DOC20/917109  
Senders ref: SSD 10440

**Subject: Notice of Exhibition – Waterloo Metro Quarter Over Station Development – Northern Precinct (SSD 10440)**

Figure 2. Shelter areas and evacuation route - Northern precinct (ground level)

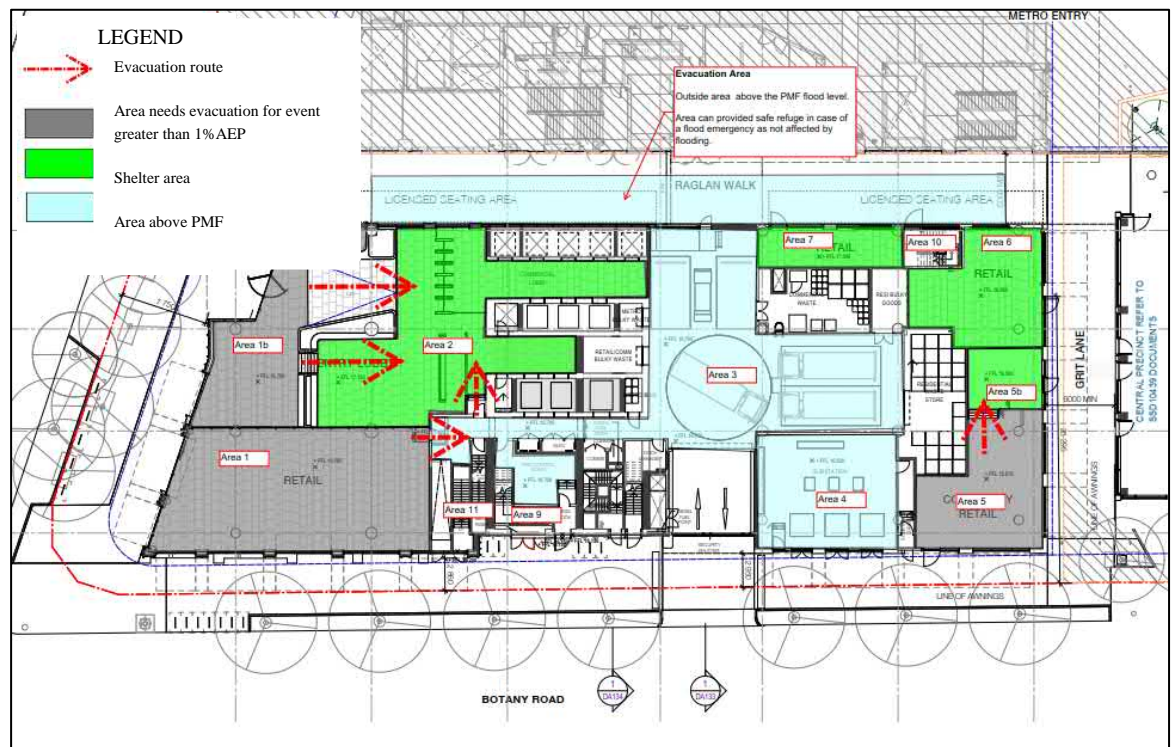
An attempt has been made to identify areas where occupants could shelter in place. However, no consideration has been given to the number of persons at risk and whether there is enough space for these individuals in the nominated shelter areas. Any persons in external licenced seating areas, must be accounted for in emergency planning.

All the retail tenancies are above the PMF and have internal access, which appears to be able to be used to reach upper levels in extreme flood events. The proponent needs to confirm the suitability of the shelter in place provisions.

Figure 11: Time of inundation for the PMF (30,45- and 90-minutes storms) flood event

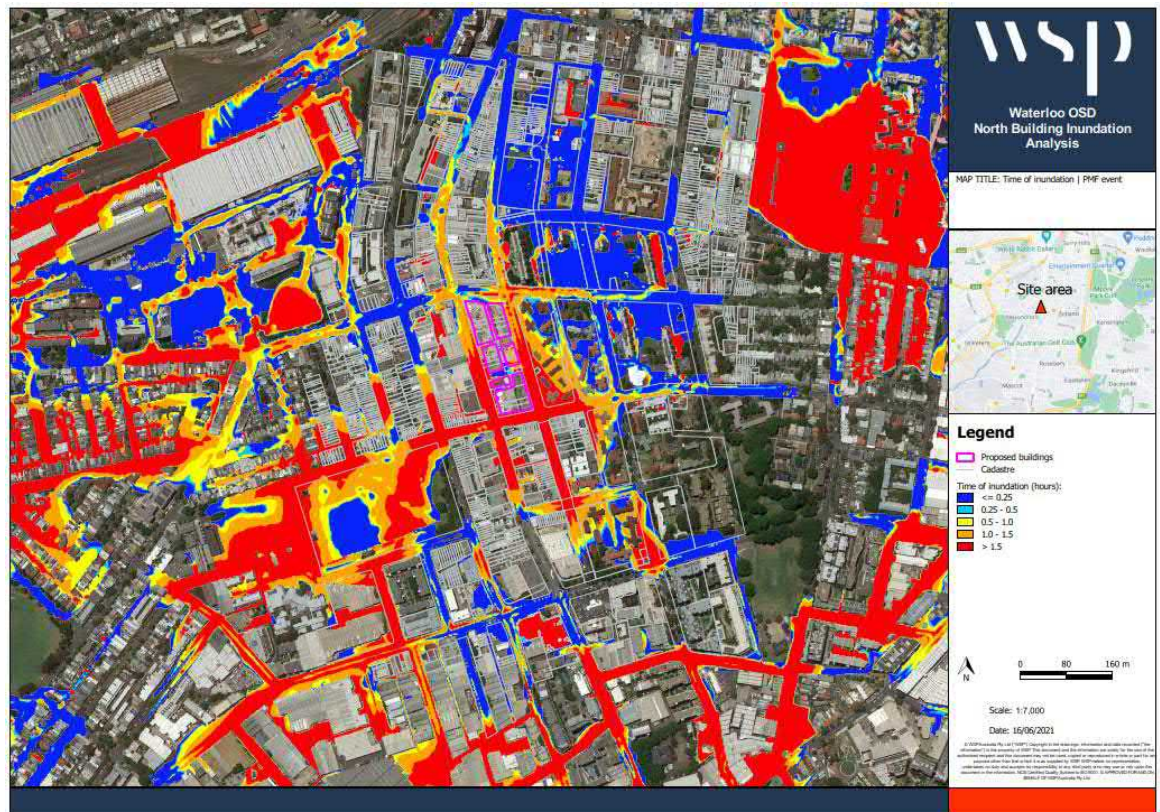
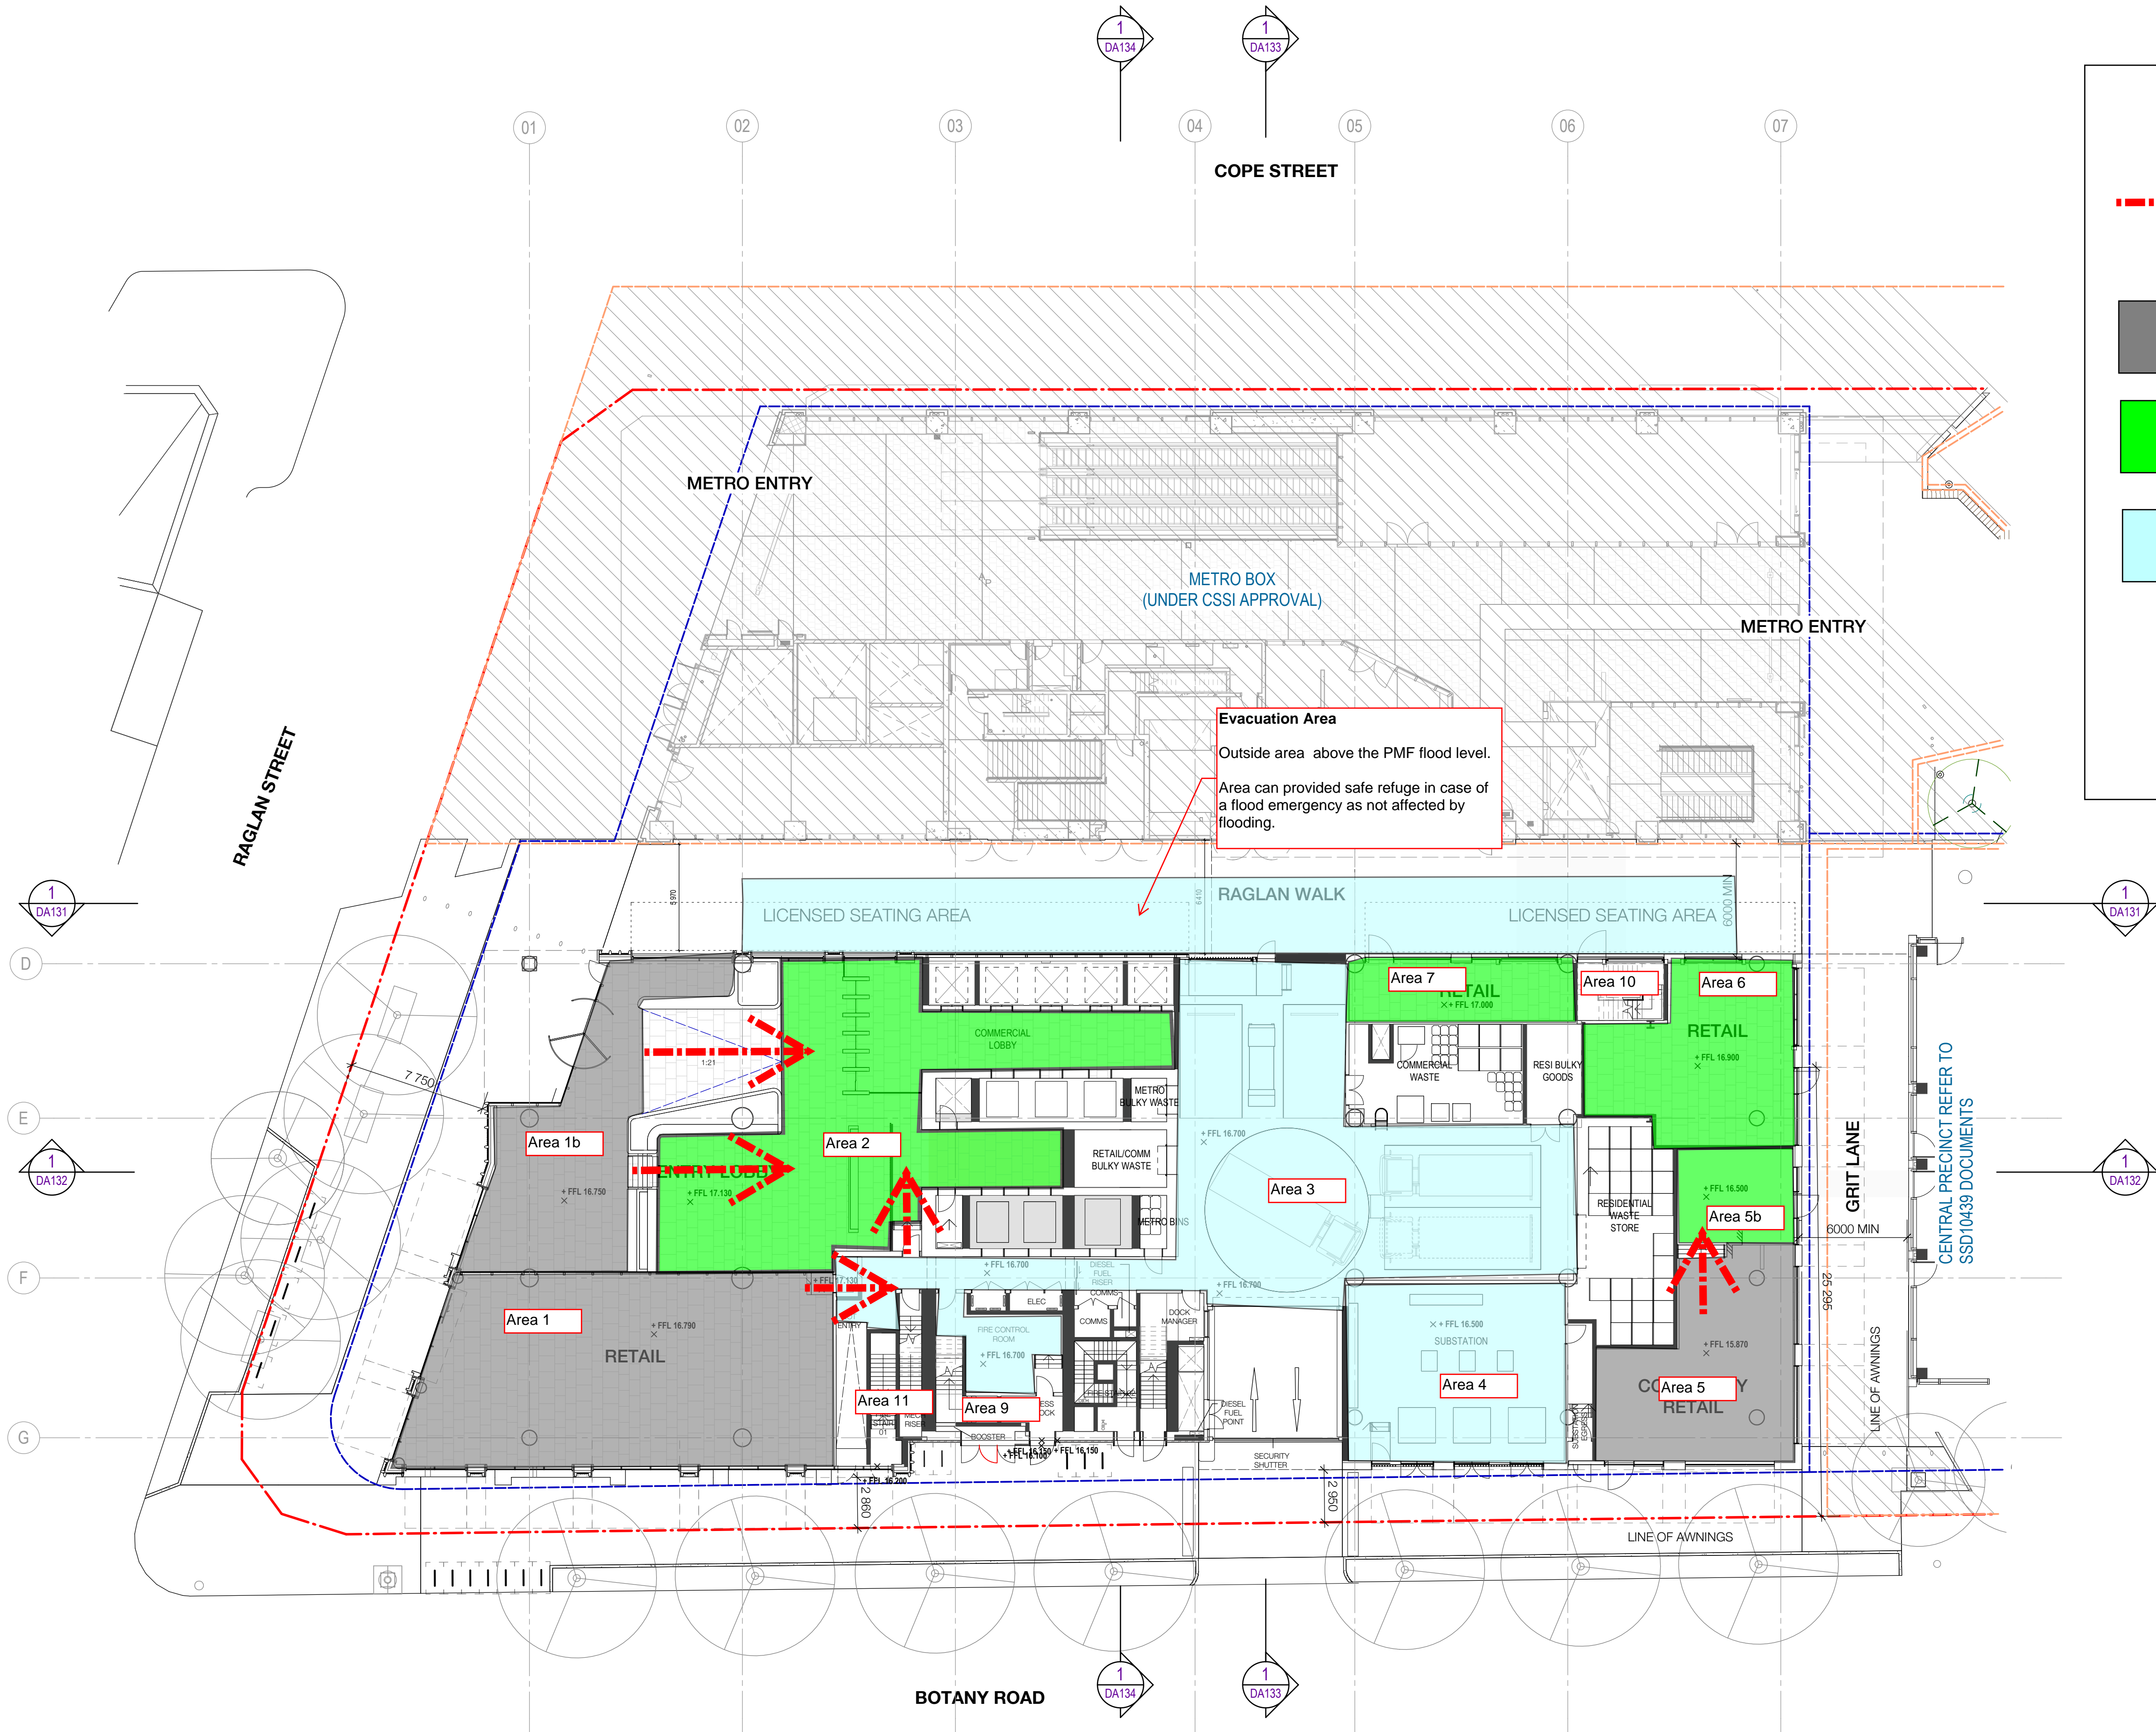
The discussion regarding timing of flooding in relation to evacuation has not demonstrated an understanding of the principles involved and is not consistent with current available guidelines. Before the proposal moves to the next stage, a proper assessment of the flood behaviour as it relates to emergency management is required, together with the development of a strategy for flood emergency management. Detailed information on the timing/duration of extreme events should be considered and presented. Shorter and longer durations should be considered for emergency planning, not only the duration that generates the peak flood level.
